Rezoning Transportation Analysis

Petition Number: 2021-178

Revision Log:

Date	Description
11/21/2021	First Review (PDM)
12/20/2021	Second Review (PDM)

SHEET NUMBER:
RZ-1

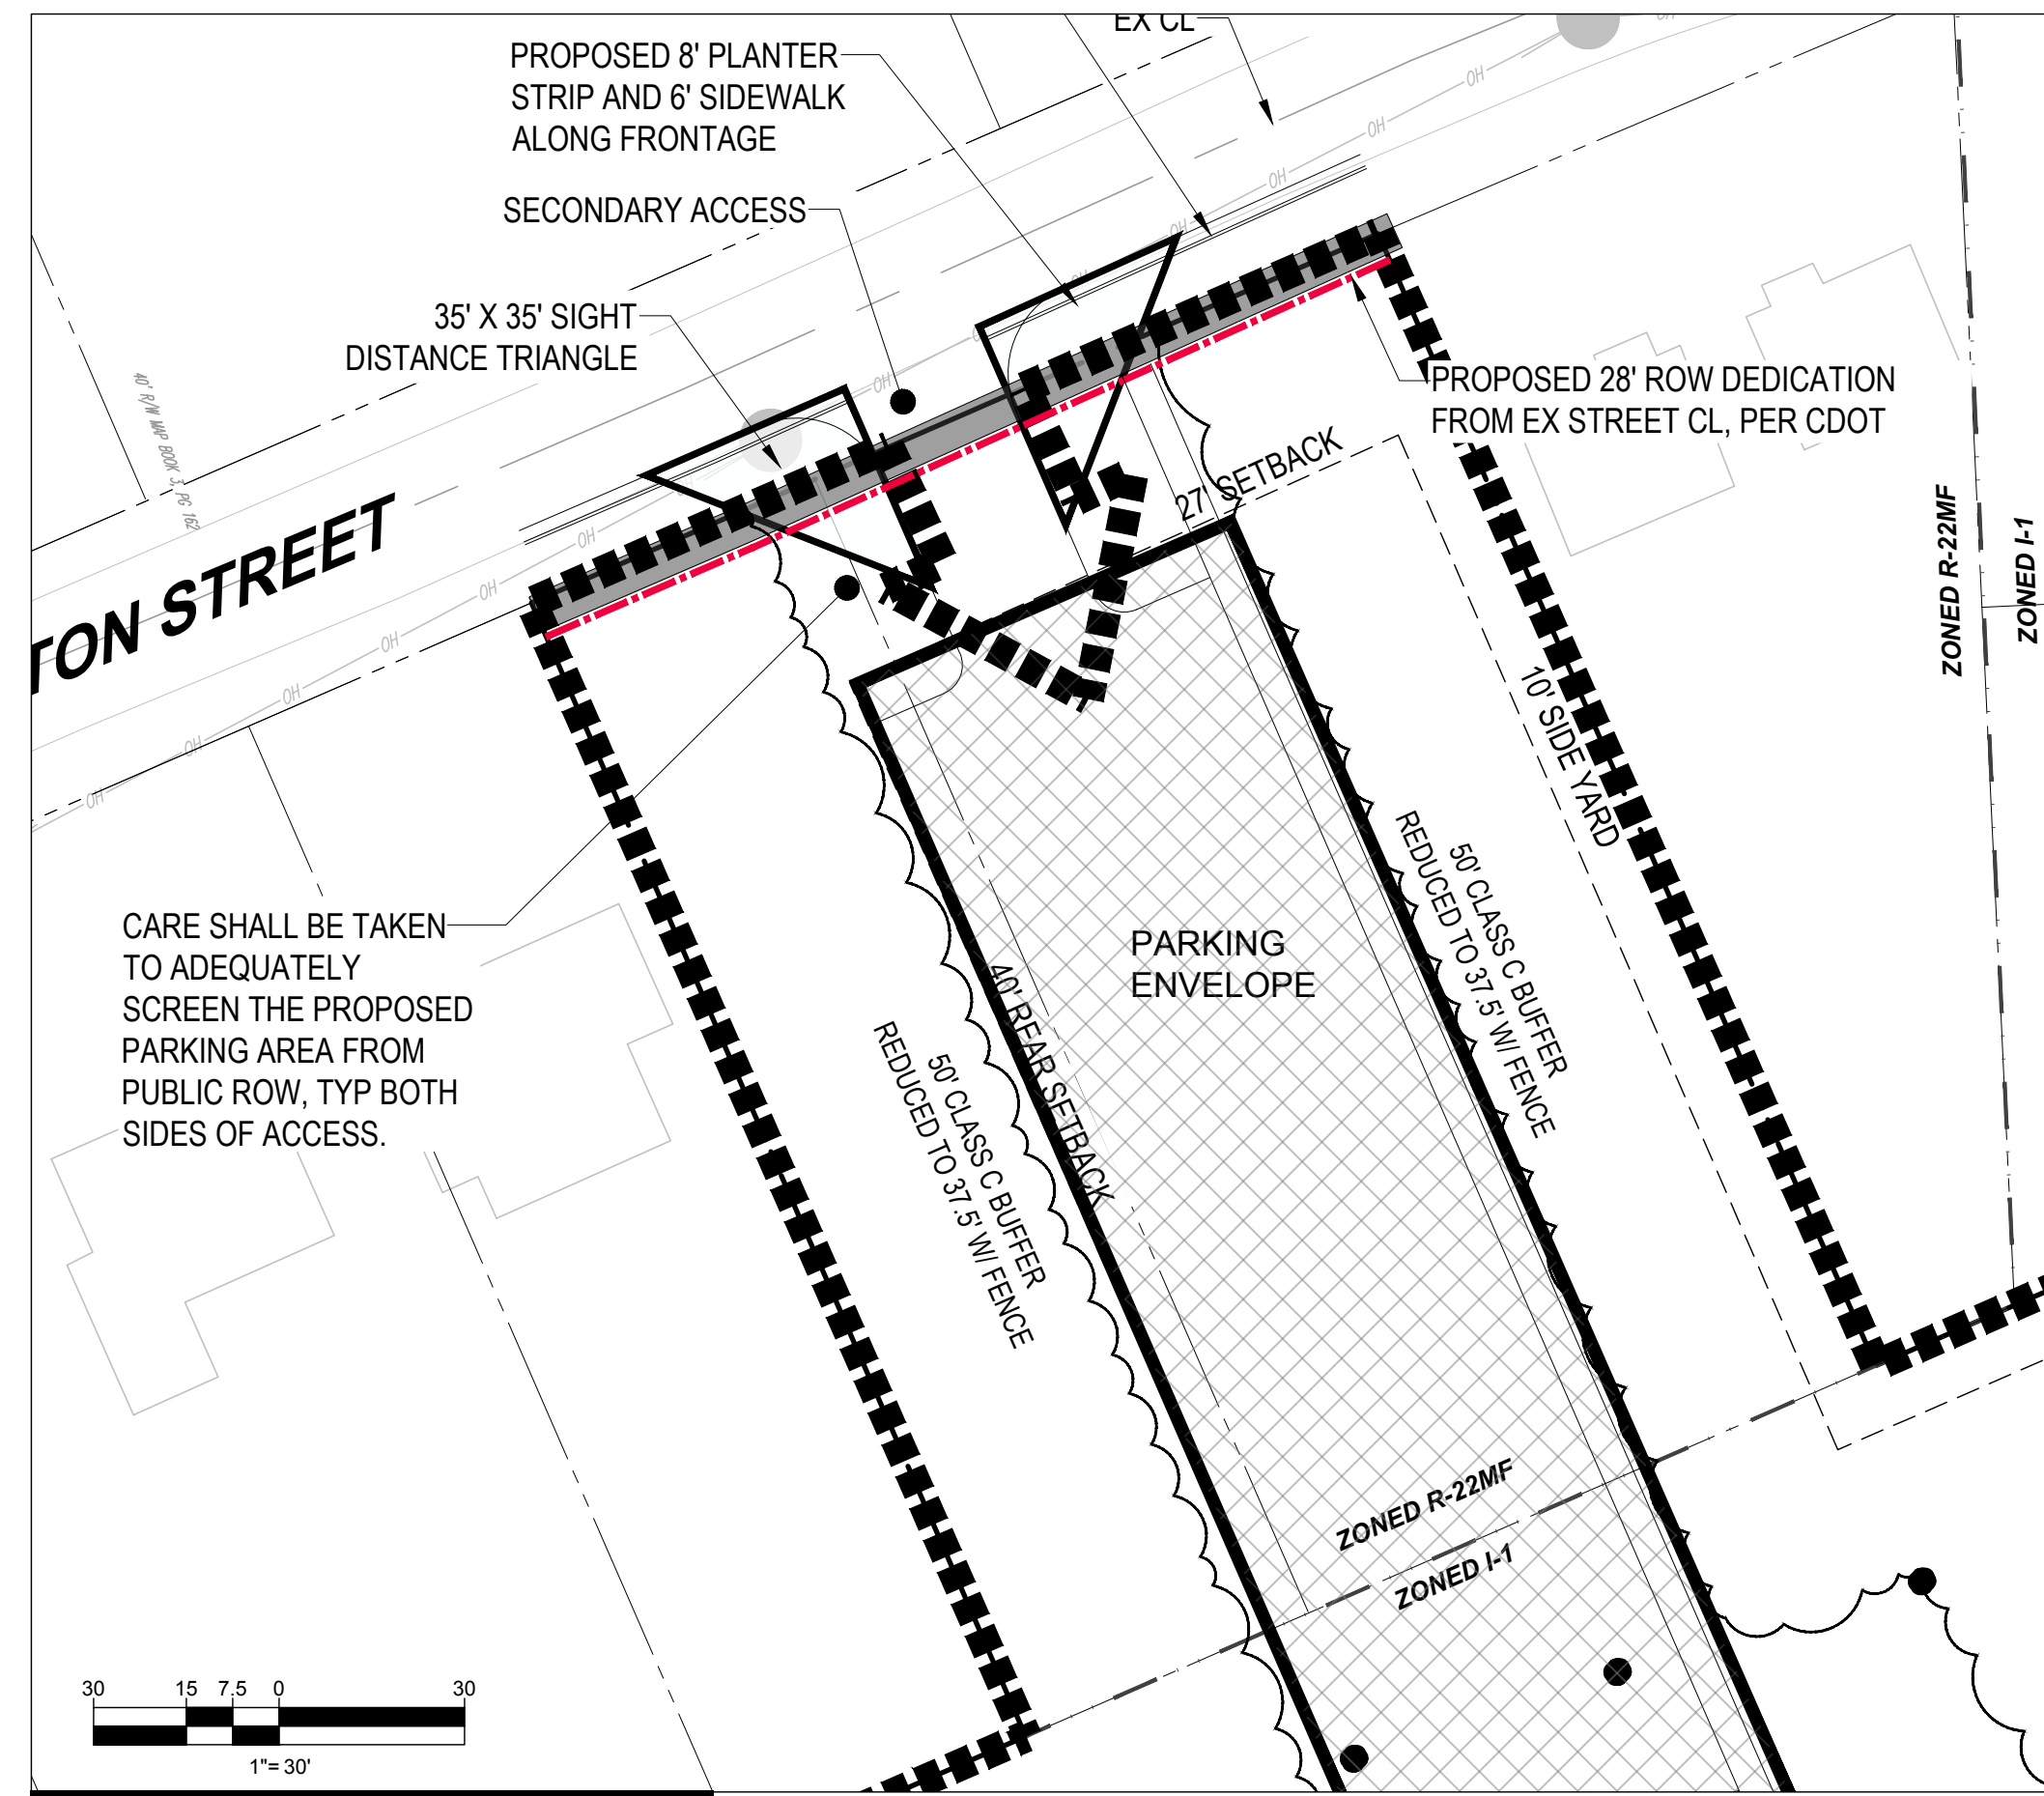
1. **Outstanding Comments from 11-21-21: Curblines:** The proposed zoning district has a setback measured from back of the existing or proposed future curblines.
 - a. **Statesville Avenue:** Location of existing curb and gutter is in the future location.
 - b. **Atando Avenue:** Location of existing curb and gutter is in the future location.

Label and dimension the curb and gutter from the centerline for each road on the site plan.

3. Revise site plan and conditional note(s) to commit to dedicate 28 feet of right-of-way from the road centerline of Whittington Street. The site plan shall label and dimension the right-of-way from the road centerline.

Outstanding Comments from 11-21-21: Show centerline of Whittington Street on site plan and dimension the proposed ROW from the centerline.
4. Revise site plan to label and dimension right-of-way on Statesville Avenue and Atando Avenue.

Outstanding Comments from 11-21-21: Show centerline of Statesville Avenue on site plan and dimension the proposed ROW from the centerline.
5. The proposed dwelling units exceeds 12 per acre. Per Chapter 20 Subdivision ordinance, site plan and conditional note(s) revisions are needed to commit to construct an 8-foot planting strip, and 12-foot multi-use path along Statesville Avenue and Atando Avenue. The wider sidewalk also meets the Charlotte WALKS Policy and Charlotte BIKES Policies.

Outstanding Comments from 11-21-21: Show and label the 8-foot planting strip along Stateville Avenue. Add conditional note committing to the installation of the 8-foot planting strip and 12-foot multi-use path along Statesville Ave.

9. **Outstanding Comments from 11-21-21:** Revise site plan to install curb and gutter along property frontage of Whittington Street per Chapter 19 and Chapter 20. Refer to CLDSM U-02 for Local Residential Medium Street cross-section.

10. Revise site plan and conditional note(s) to commit to construct an 8-foot planting strip, and 6-foot sidewalk on Whittington Street per Chapter 19. The site plan shall label and dimension both items from the back of curb and gutter and road centerline.
Outstanding Comments from 11-21-21: Add conditional note committing to the 8-foot planting strip and 6-foot sidewalk on Whittington Street

CURRENT PARKING FIELD

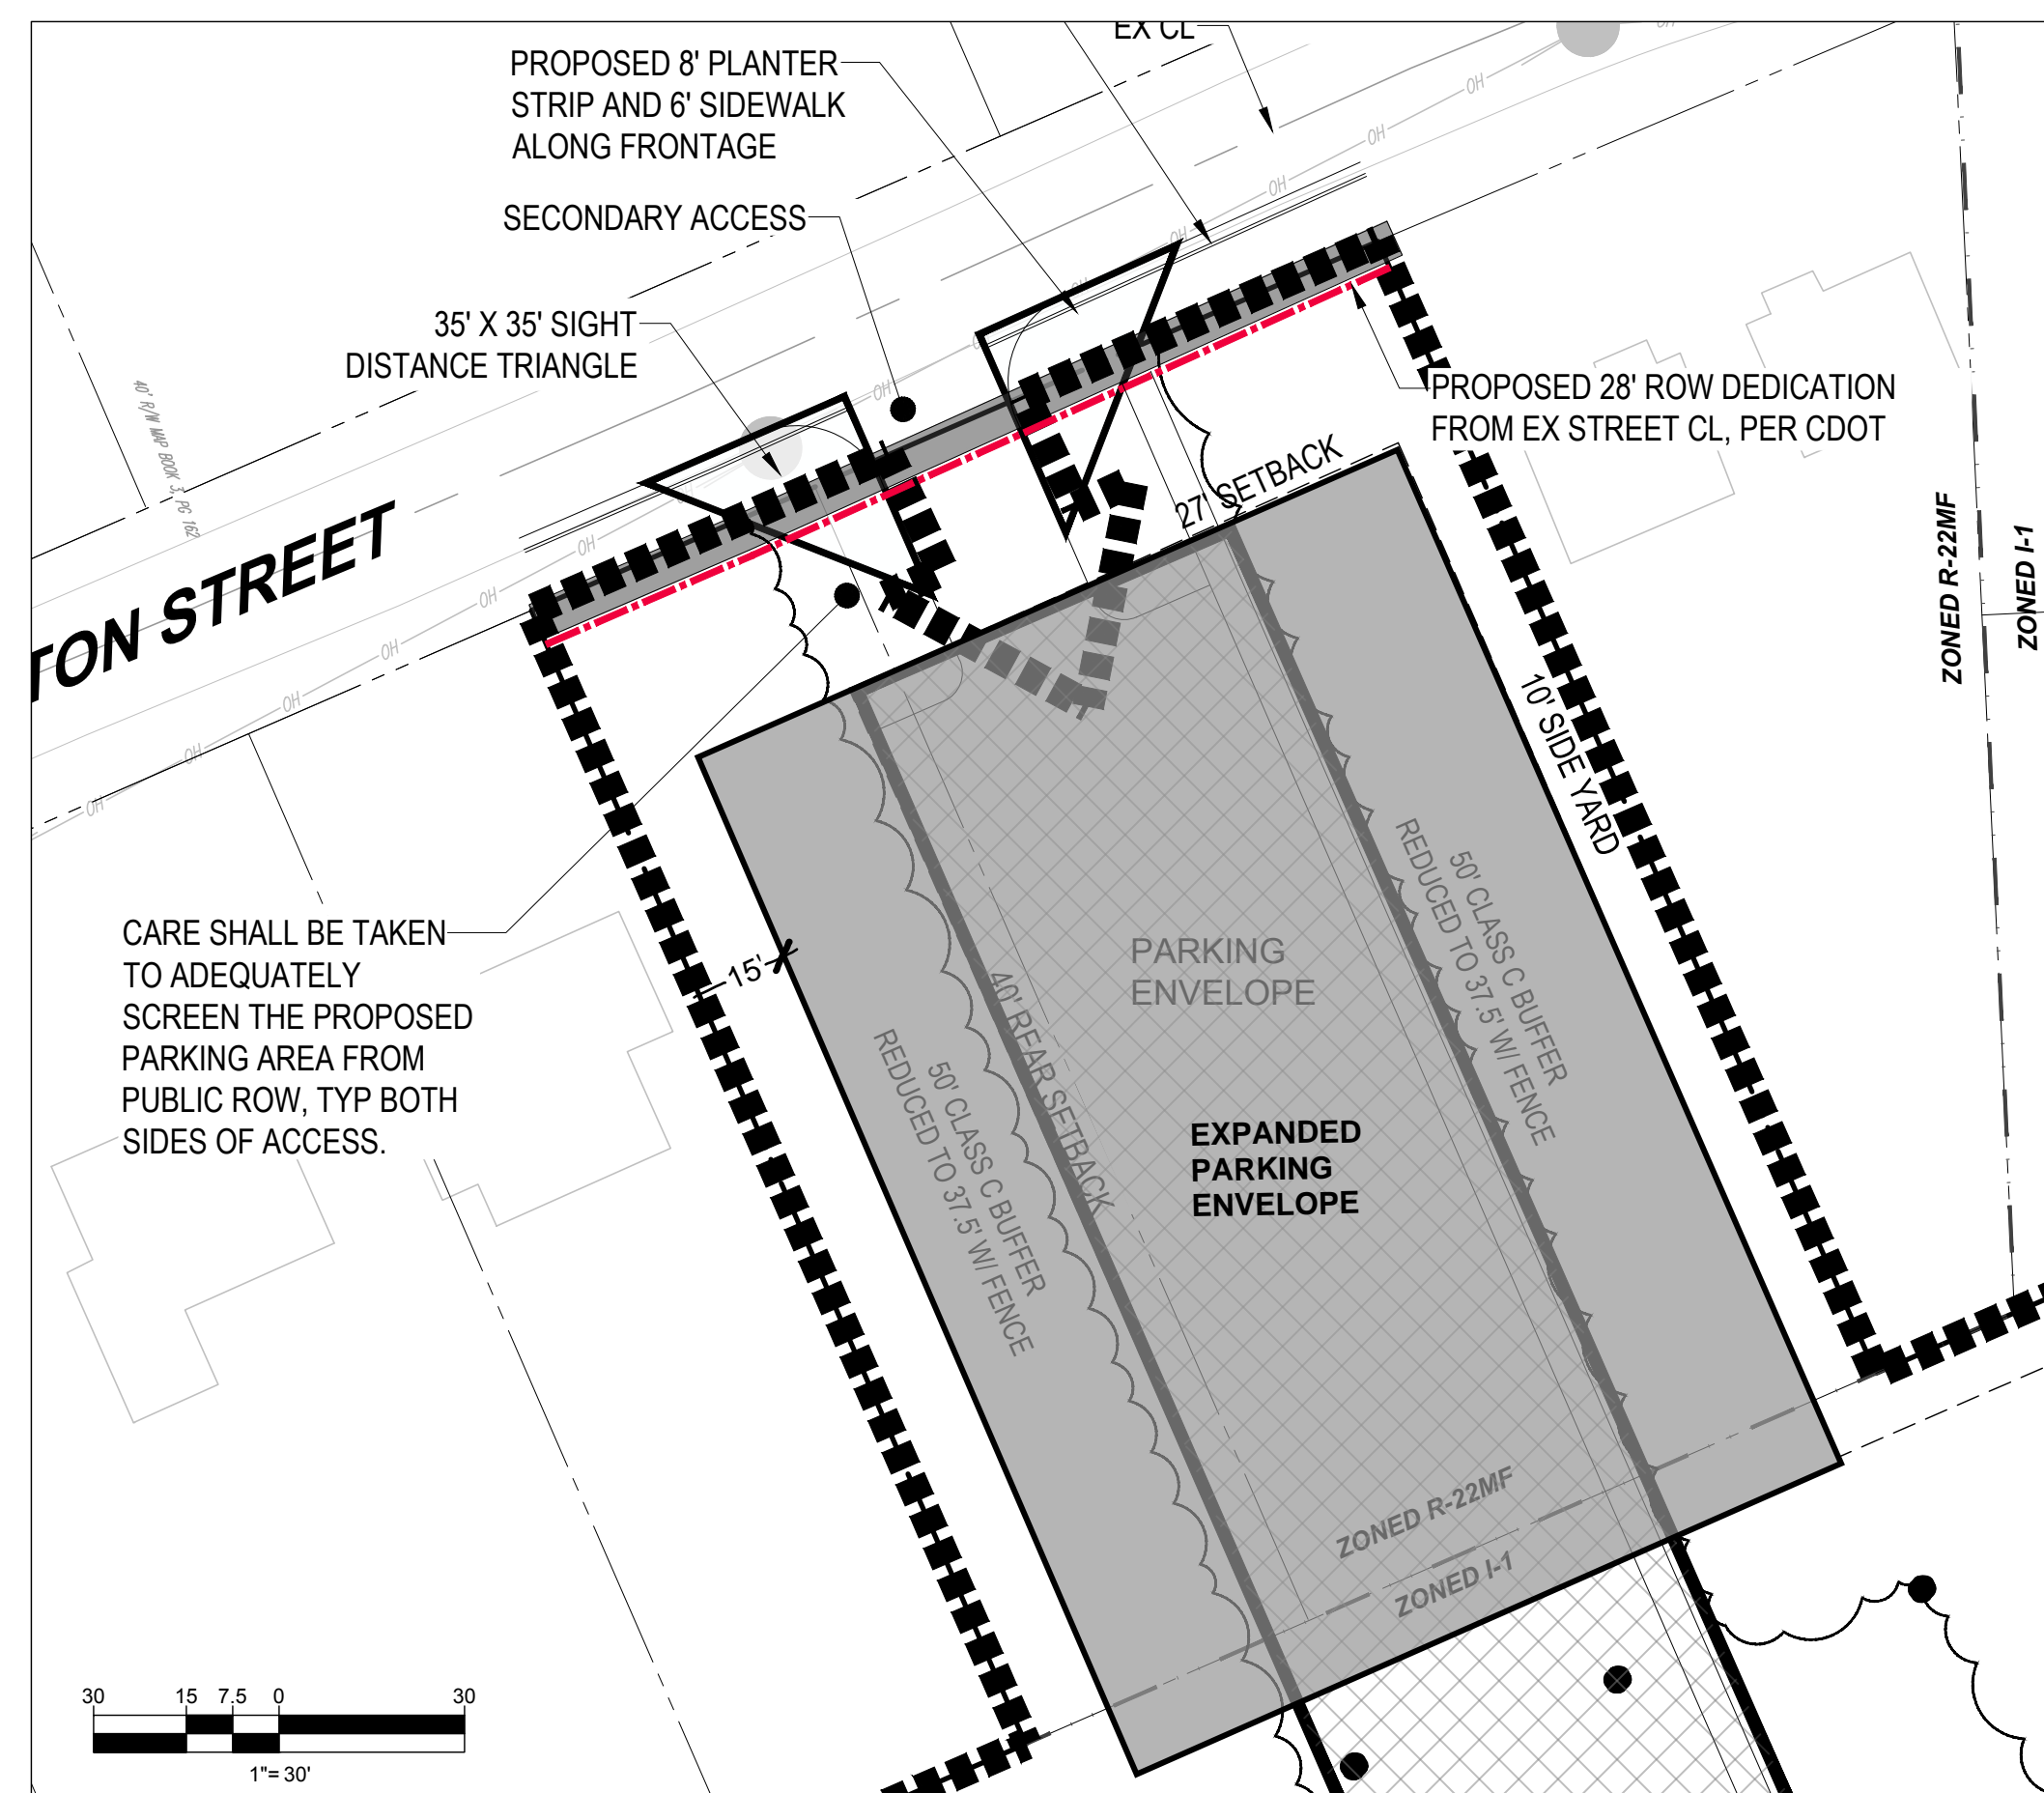
11. **Outstanding Comments from 11-21-21:** Revise site plan and conditional note(s) to commit to installing a local residential median street per CLDSM U-02 (**Request**) or a 12-foot multi-use path (**Required**) connecting Whittington Street to Julia Avenue.
